Application Reference: 2025/0203

Site Address: 25 Hollin Moor View, Thurgoland, Barnsley, S36 7EE

This application seeks full planning permission for the erection of a single storey front and rear extensions to dwelling, located at 25 Hollin Moor View, Thurgoland, Barnsley, S36 7EE.

1 PROPOSED FRONT ELEVATION
SCALE: 1:100

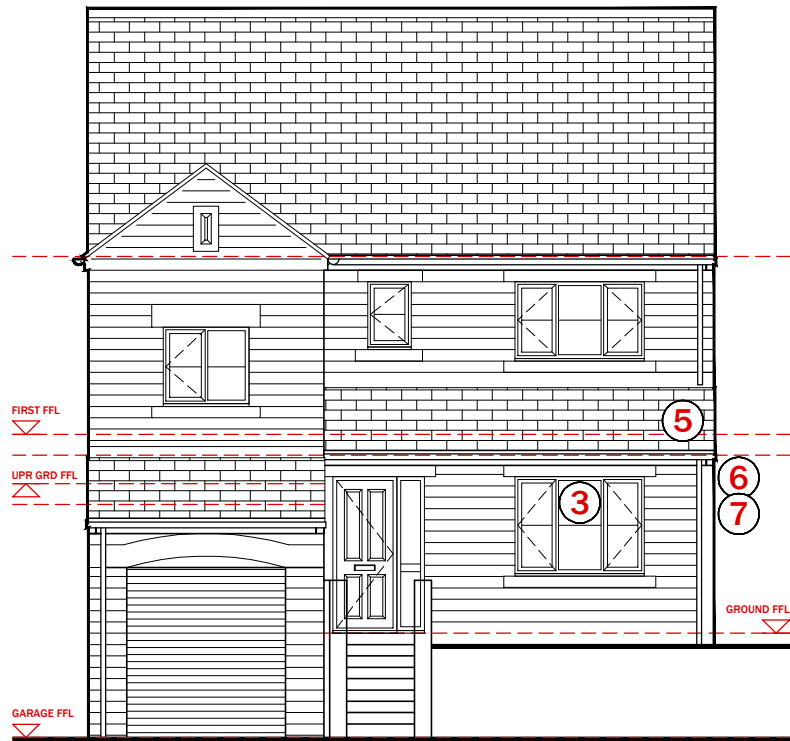
There are examples of this kind of development nearby at other residential properties which have expanded the residential space to the front and rear. The extension to the front would extend to the building line of the porch, however not as far as the garage. The front extension would have a sloped roof to integrate with the existing porch and would use matching materials.

3 PROPOSED REAR ELEVATION
SCALE: 1:100

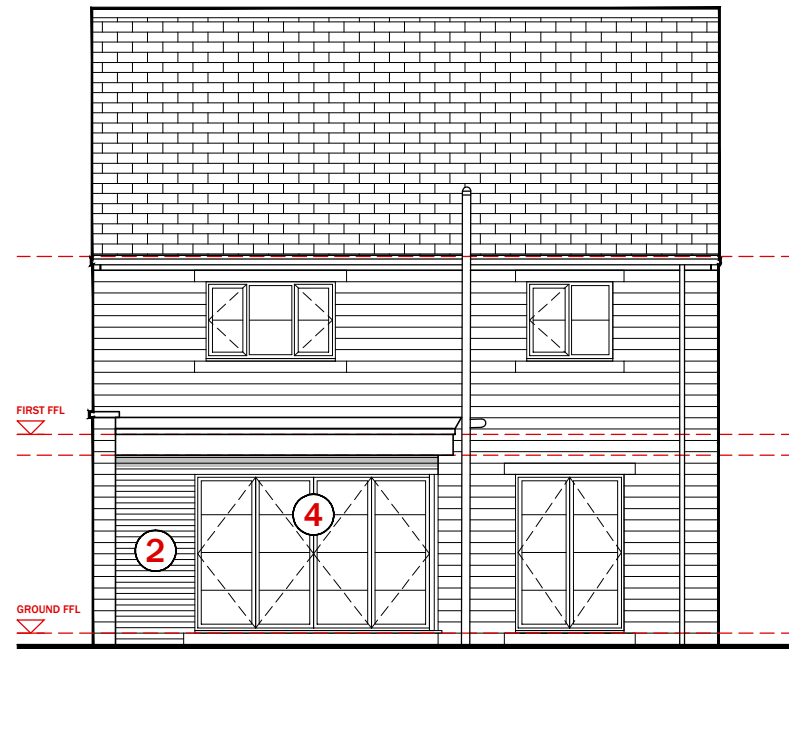
The rear extension would have a flat roof and would provide additional space for the kitchen/dining area. It should be noted that the rear extension would be acceptable in regard to permitted development in terms of its size, however as the applicant is using a mix of reclaimed brick and stone (side elevation). The stone wall would be seen to the side of the property and would hide the reclaimed brick design to the rear and as such would not be seen by the general public. As such it would not have a detrimental impact on the character of the area. The design and scale would therefore be acceptable in this regard.

Flat roof to the rear is incongruous – Whilst it is accepted that the LPA does not support flat roofs as they are not in keeping with the character of the area. The flat roof extension would be situated at the rear of the property where it cannot be seen from the street. As such it would not have a detrimental impact on the street scene. It should also be noted that there are similar rear extensions in the area which also have flat roofs.

4 PROPOSED LH SIDE ELEVATION
SCALE: 1:100

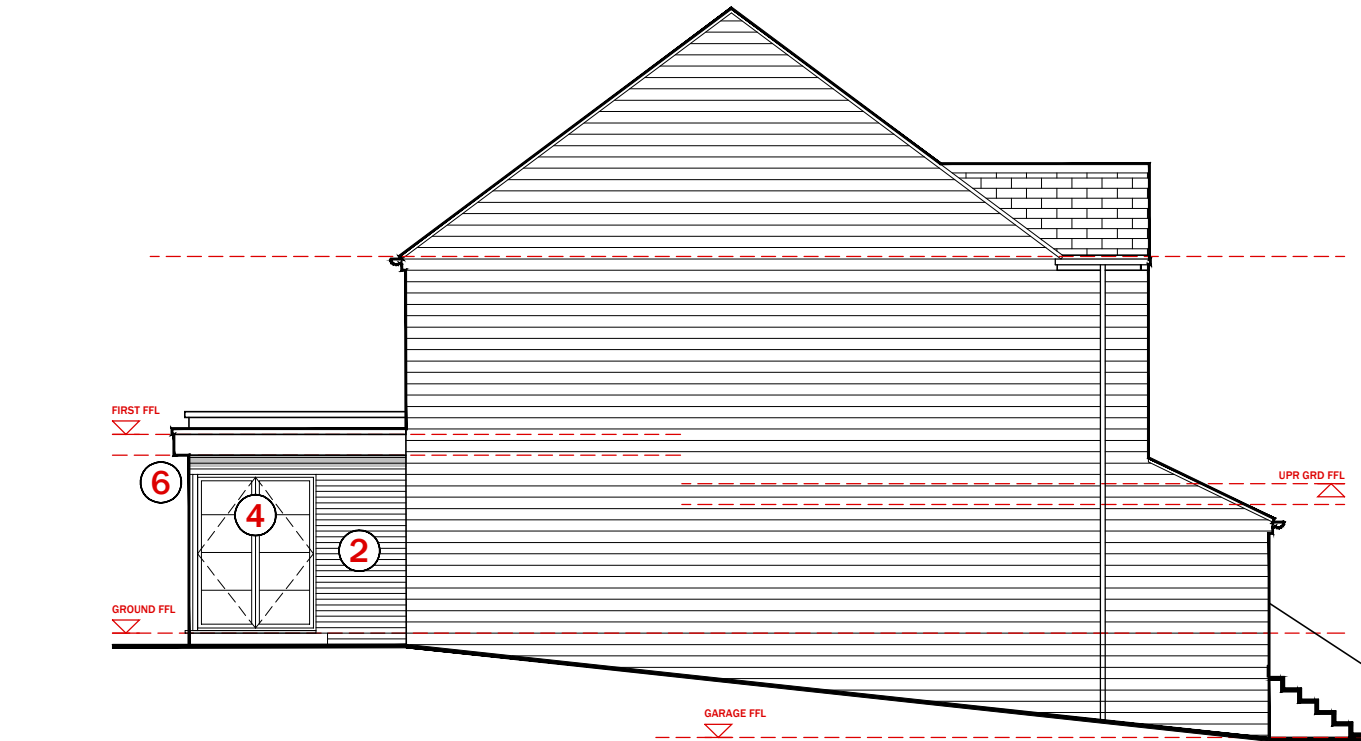
with permitted development rights apart from the use of reclaimed brick which will be used. Currently the scheme would not comply with the 45- degree code and as such could have a detrimental impact on neighbouring amenity. However, there are mitigating circumstances, such as the original dwelling and how it is plotted already breaks the 45-degree code and that the scheme would comply with permitted development apart from the materials. The neighbouring rear window situated on the rear of garage of 27 Hollin Moor View appears to be a secondary window. Therefore, even if this application was refused the applicant would be able to construct the rear extension under permitted development rights providing that the all the materials were matching.

Height of the rear elevation is too large and proximity to boundary is too close – The neighbour has claimed that the rear extension would be too close to the boundary and too large. They claim that the scheme would be 3.2m, after using the Council's measuring tools it has been concluded that the height of the rear elevation wall would be 3m, as explained in the report previously. As such this would comply with the permitted development requirements and even if a refusal was given the applicant would still be able to construct the proposal without planning permission, providing all of the materials matched.
